GELOTTE HOMMAS DRIVDAHL
ARCHITECTURE

RE: Seifert Remodel & Addition

Building Permit # 2403-052

Land Use Permit # SHL24-005

FIGURE 1: EXISTING SITE PLAN  
 PRELIMINARY SHORELINE MITIGATION PLAN  
 SEIFERT PROPERTY  
 3261 67TH AVE. SE  
 MERCER ISLAND, WA 98040  
 PARCEL 370890-0065

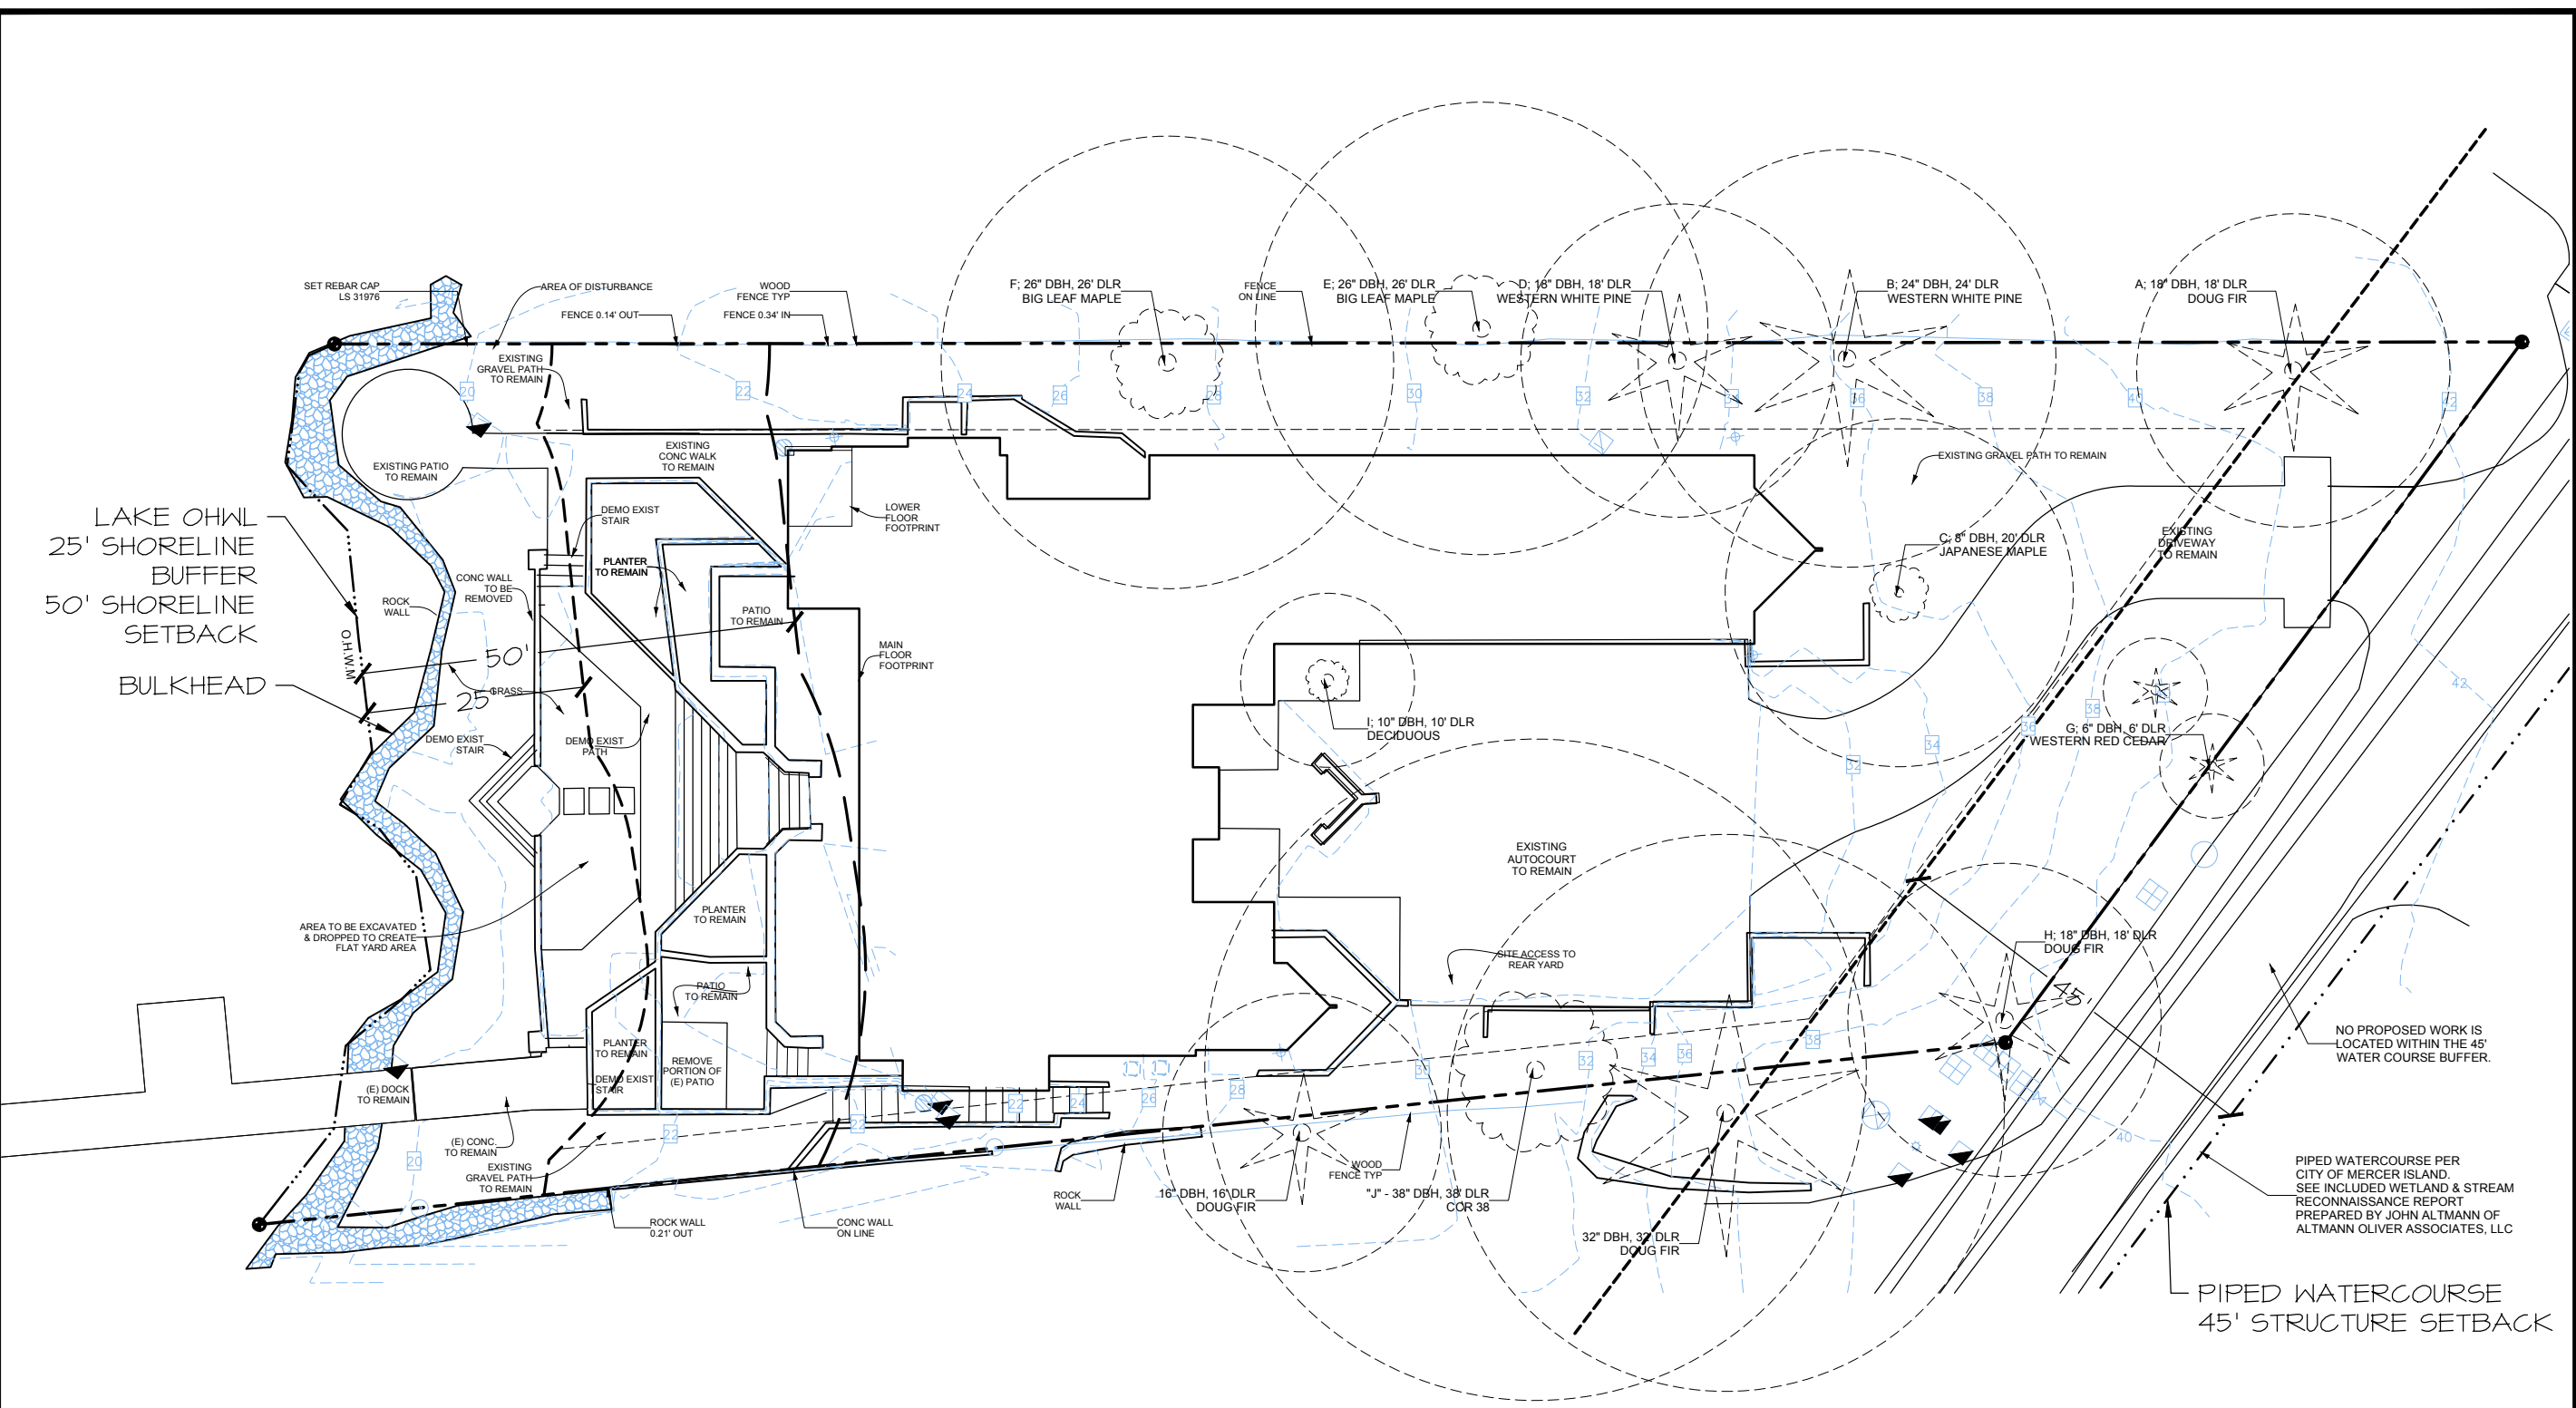
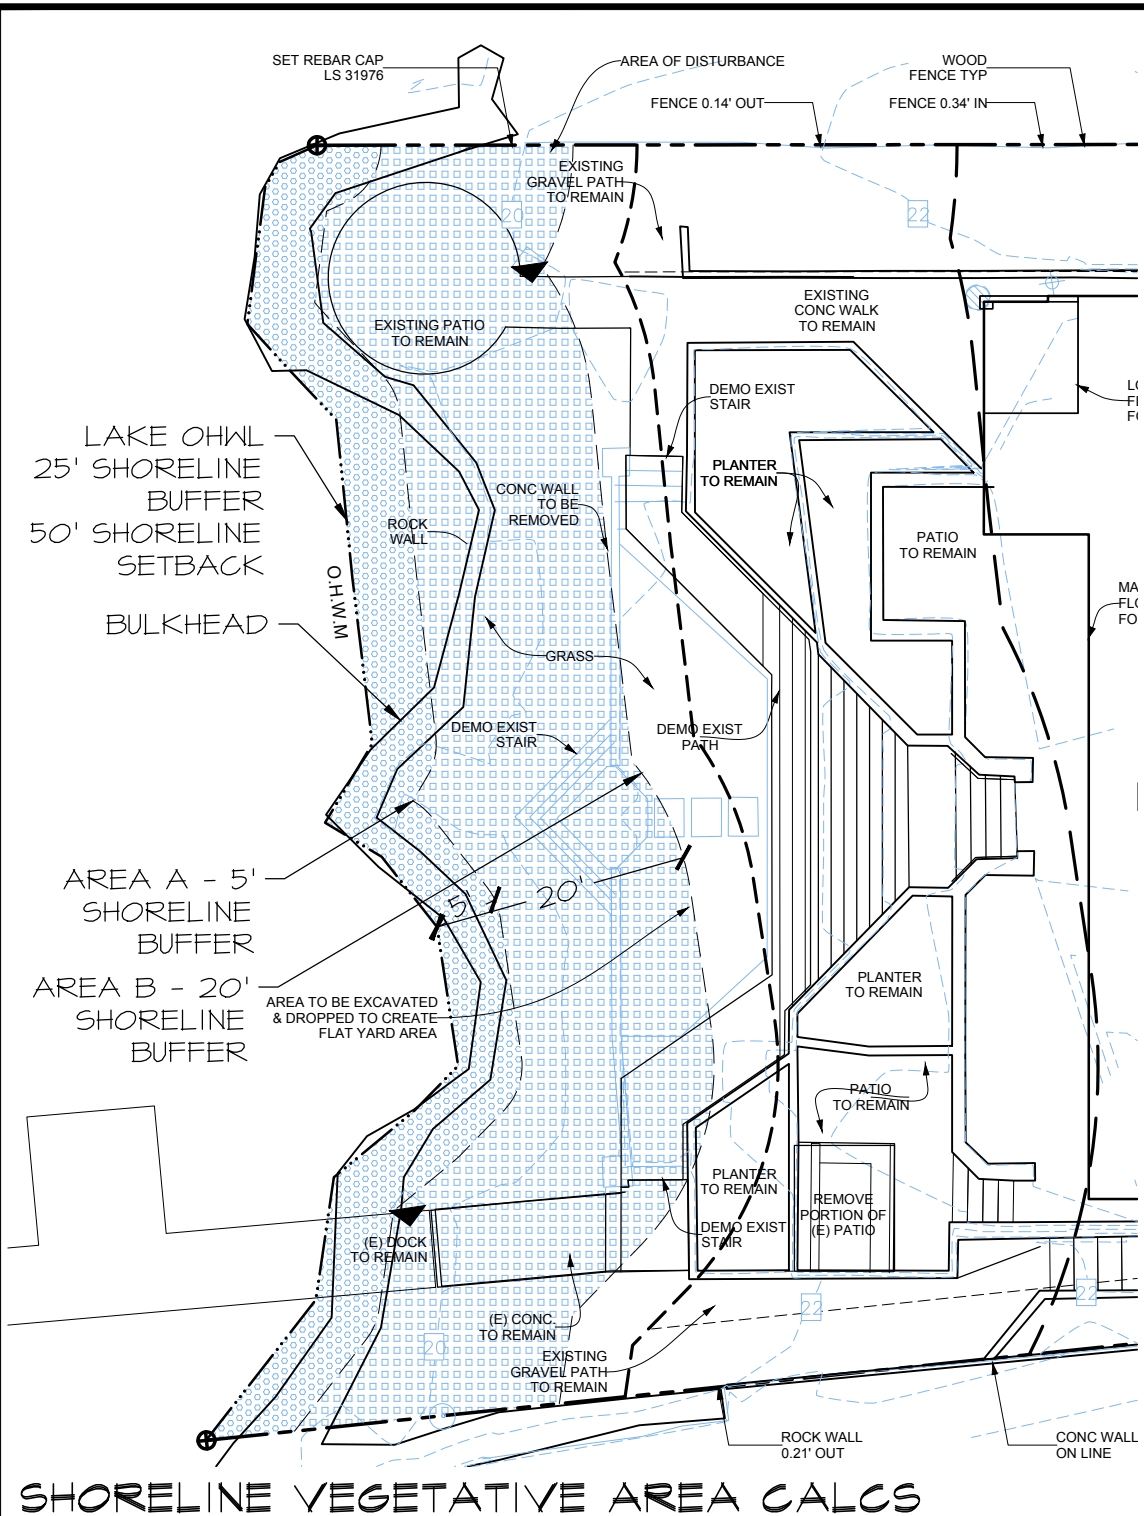
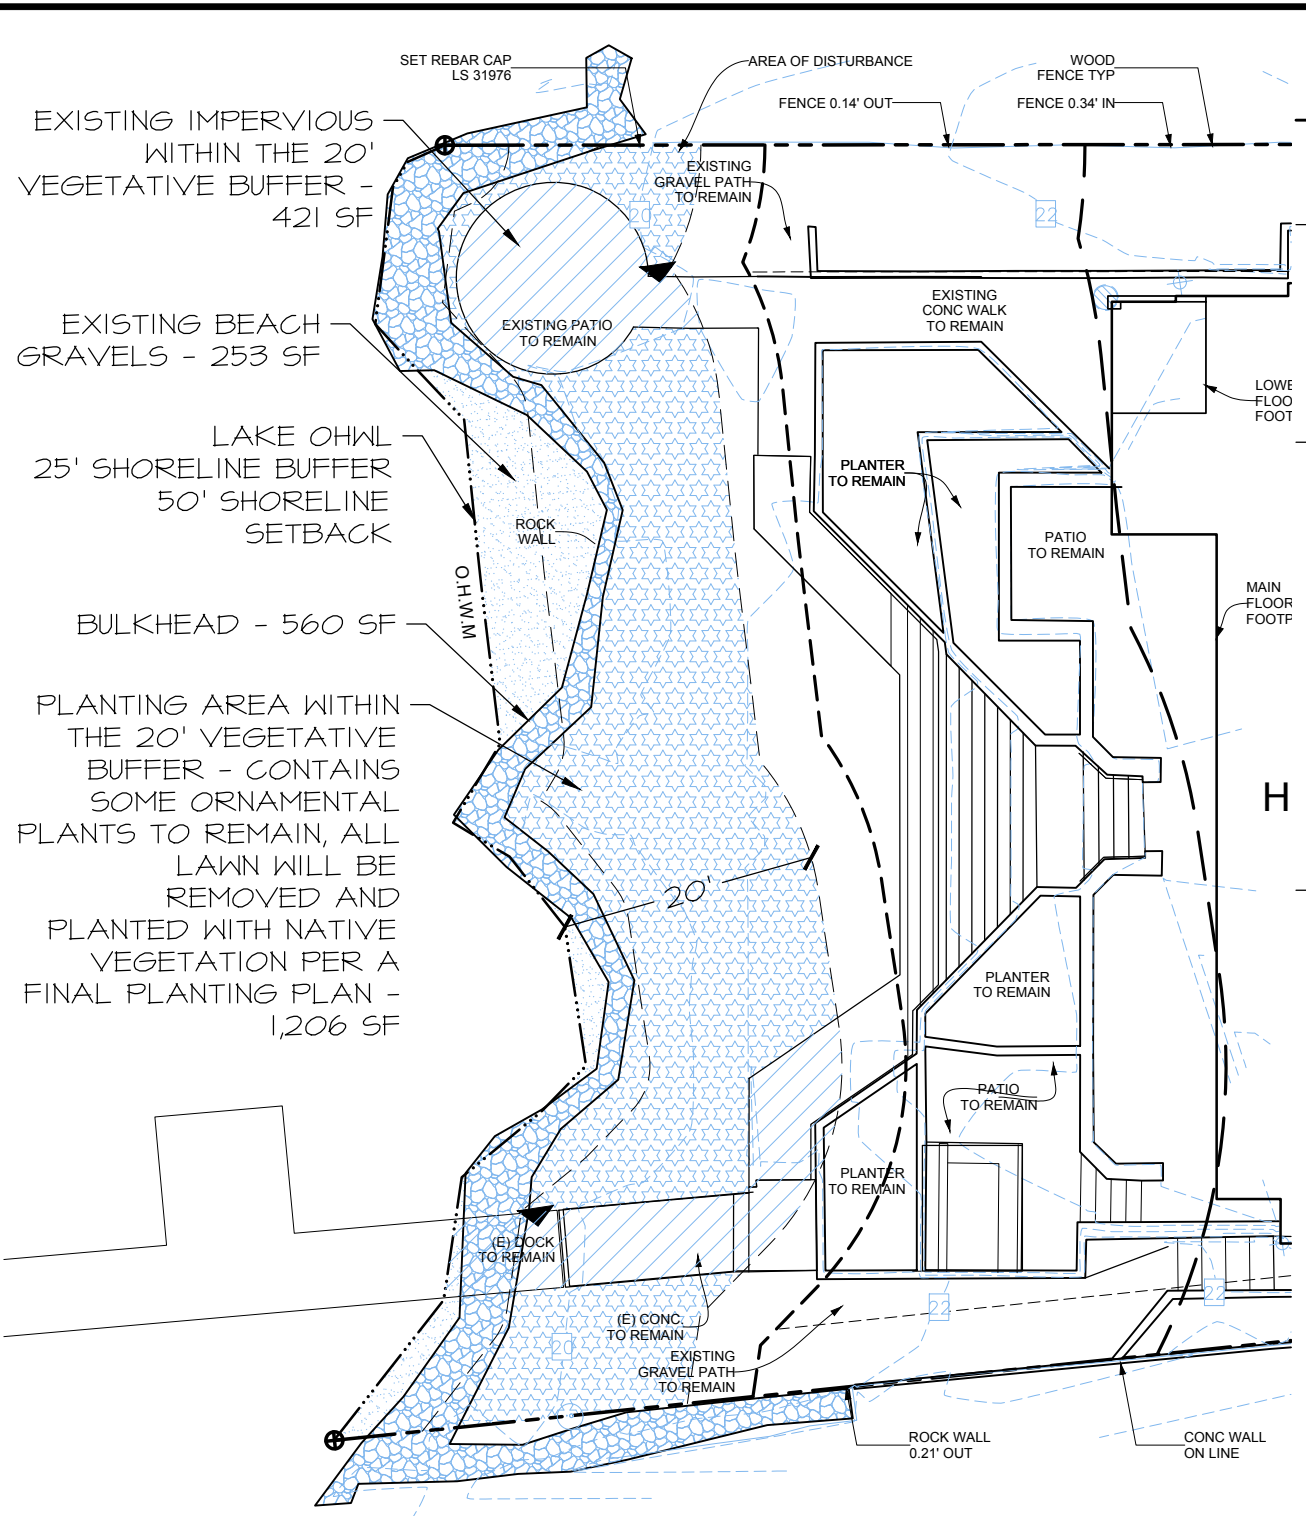
Please reference the updated plan set showing the existing legal non-conforming structures, walkways, lawn and grading in the area 25' landward from the OHWM and westward from existing planters and site stairs to remain. Likewise, please remove the Altman Oliver Associates plans from consideration for your initial review of the project.
